PLANNING AND COMMUNITY DEVELOPMENT

Subject: MS-18-001 Yarbrough Minor Subdivision 3rd Review

### Final Plat

YARBROUGH SUBDIVISION - PT. S1/2 SE1/4 SEC. 9
T11S, R67W OF THE 6th P.M., EL PASO COUNTY, COLORADO

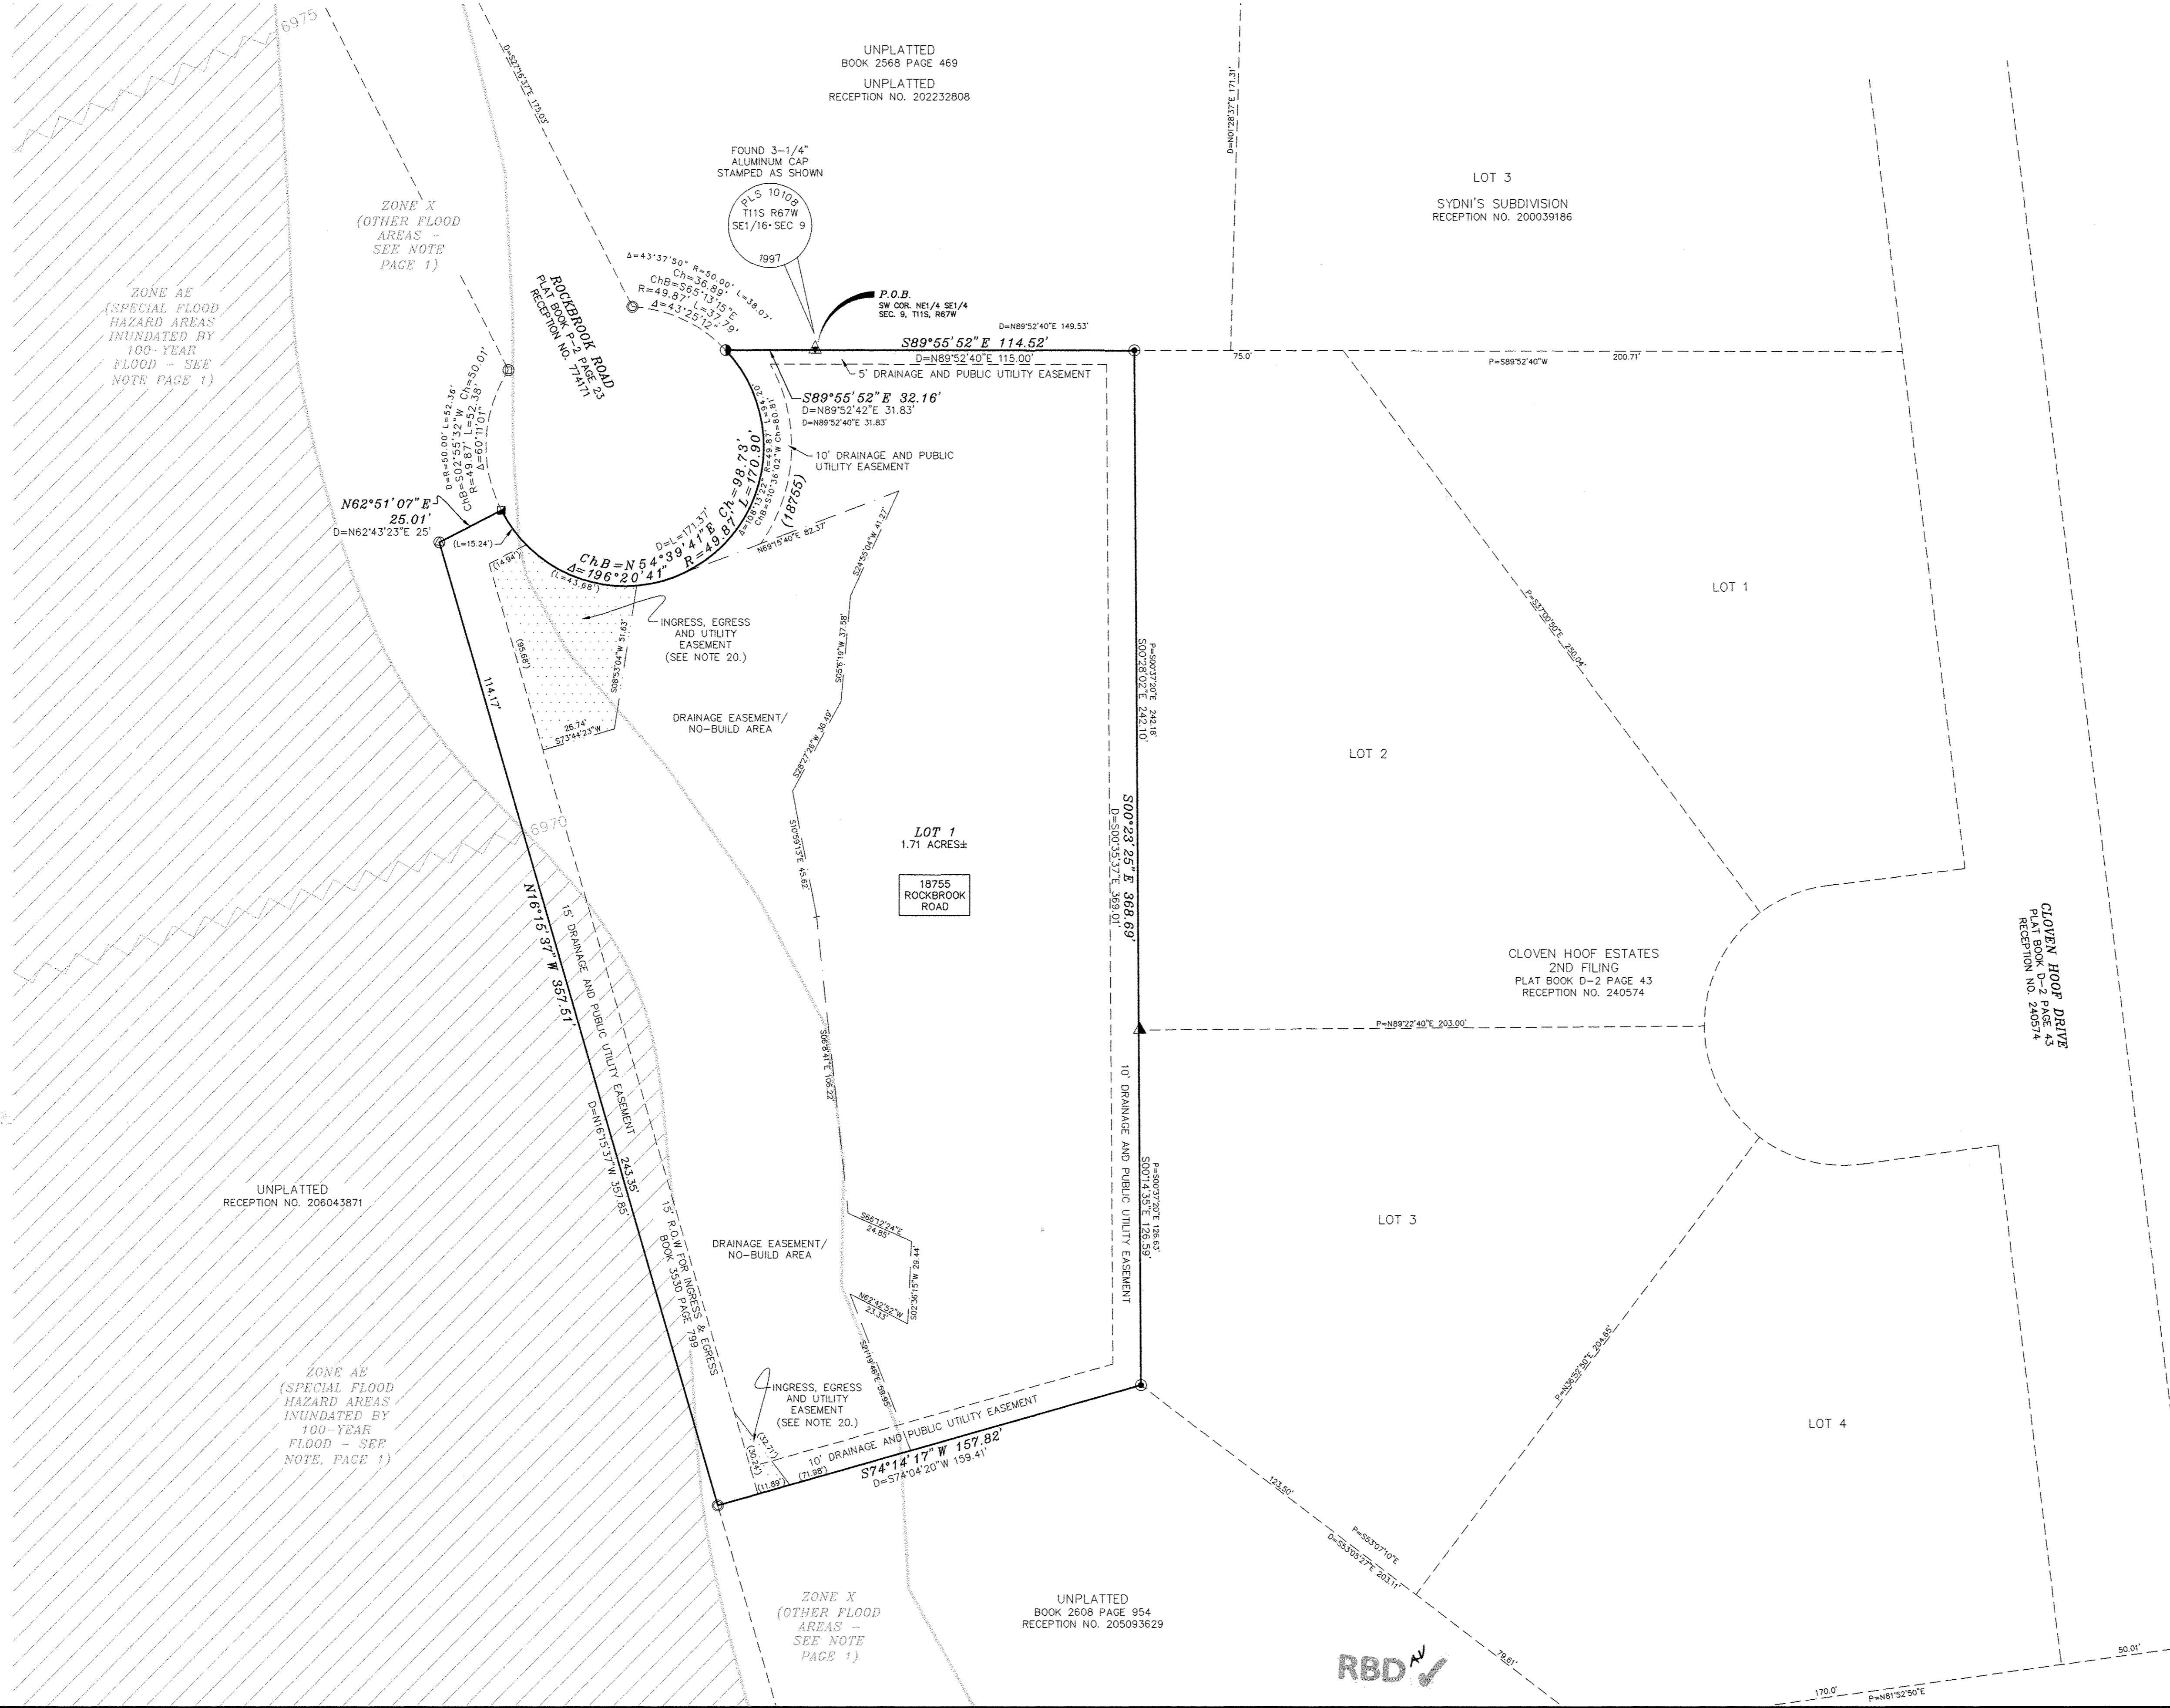
1. **Resolved**
2. In accordance with LDC Section 8.4.2(B)(1)(e), show the Federal Emergency Management Agency (FEMA)-approved base flood elevations and 100-year floodplain boundaries on the plat. If topography has changed significantly since the floodplain

study, provide a Floodplain Certification Letter by a professional engineer or architect stating that “To the best of the engineer's knowledge and based on field verified characteristics of the property, the property is reasonably safe from flooding and, if studied, the 100-year floodplain would not be shown to enter the property in question.” **Unresolved; see plat redlines and reference drainage report for location/elevations of floodplain.**

\*Comment 2: The address 18755 Rockbrook Road needs to be on the plat.

RESPONSE: Redline were sent to both surveyor and drainage engineer for final remarks, both agree that the redlines have been corrected, the 100 year floodplain are annotated on the plat and the drainage report (page 12 & 13). Please verify and let me know if you need something different, our build site is 30’ above the area refenced in the floodplain as discussed with Mr. Curtis a while ago. Do you want the elevations drawn on the plat map??

**RESPONSE:** Address was added to center of plat and also labeled on cul de'sac with just numerical annotation in parenthesis.

DEVELOPED DRAINAGE & EROSION CONTROL PLAN

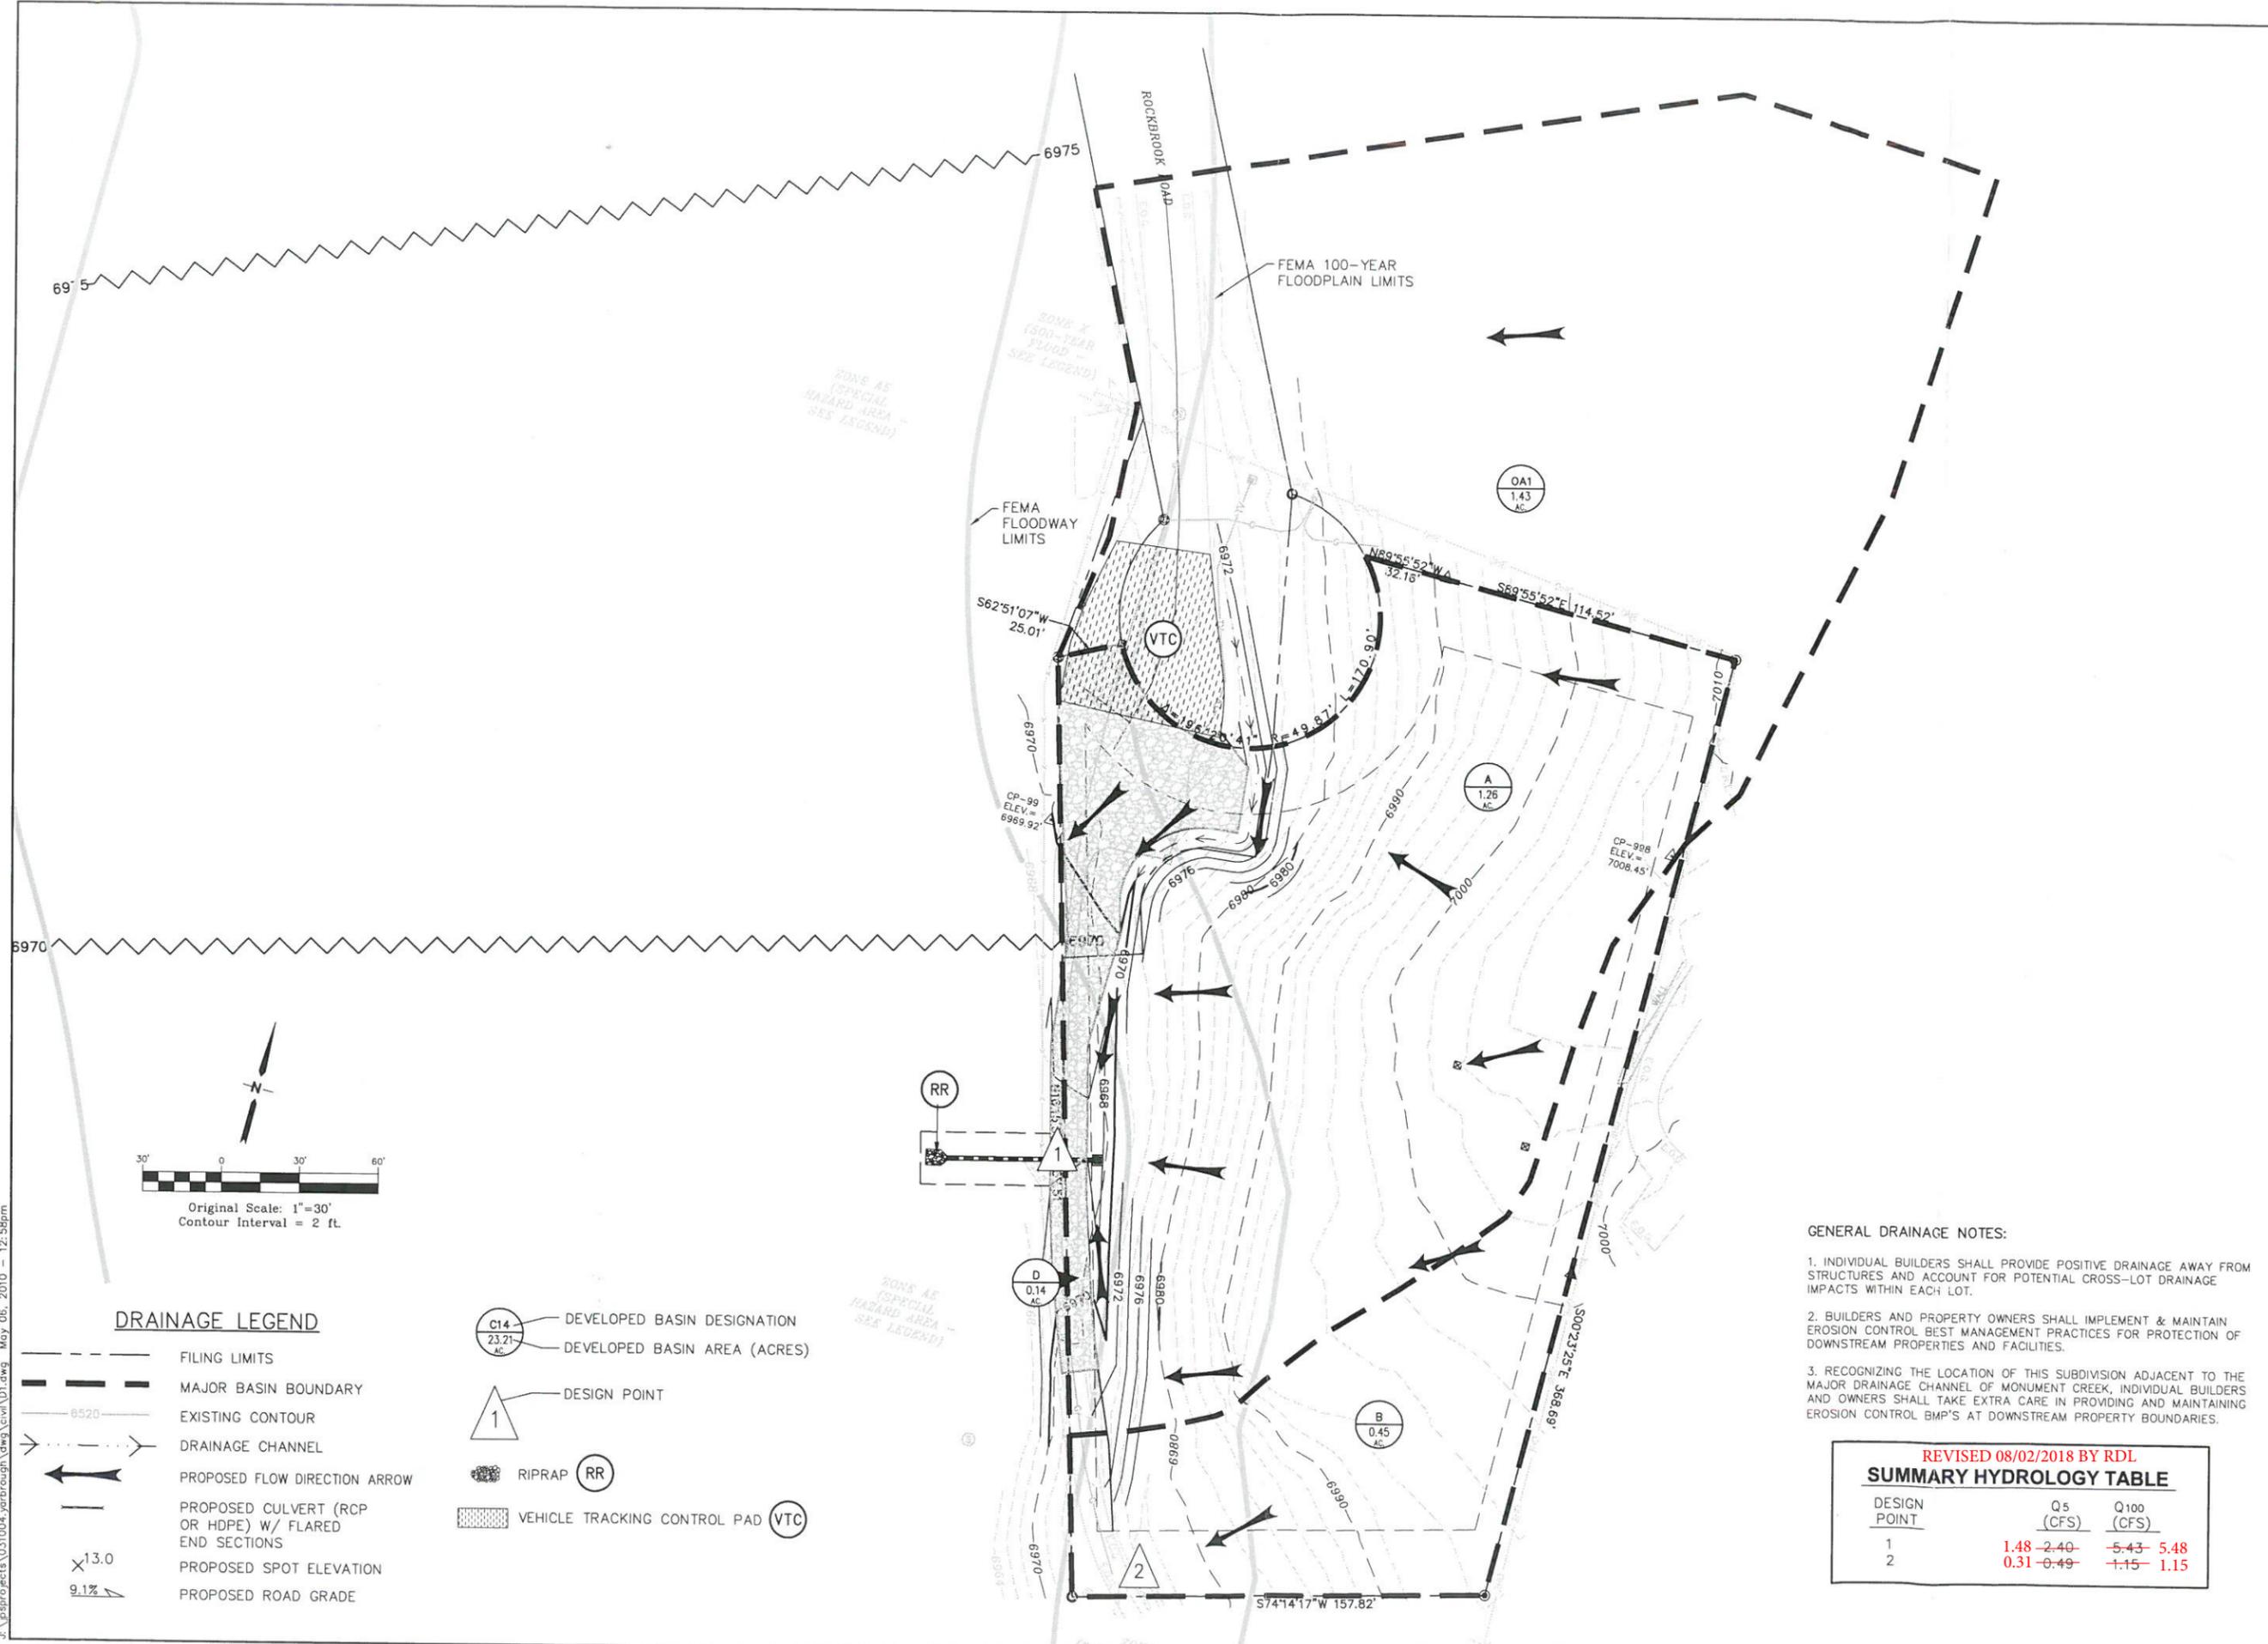
1. **through 2 – Resolved**
3. Note: If a culvert is installed per the drainage plan, a floodplain development permit and drainage easement is required. **Provide a copy of the recorded drainage easement when available.**

RESPONSE: There is no culvert being installed as mention in the original report per JPS, this would need to be completed by the builder at the time of submitting for a building permit. Engineer has blocked this are out.
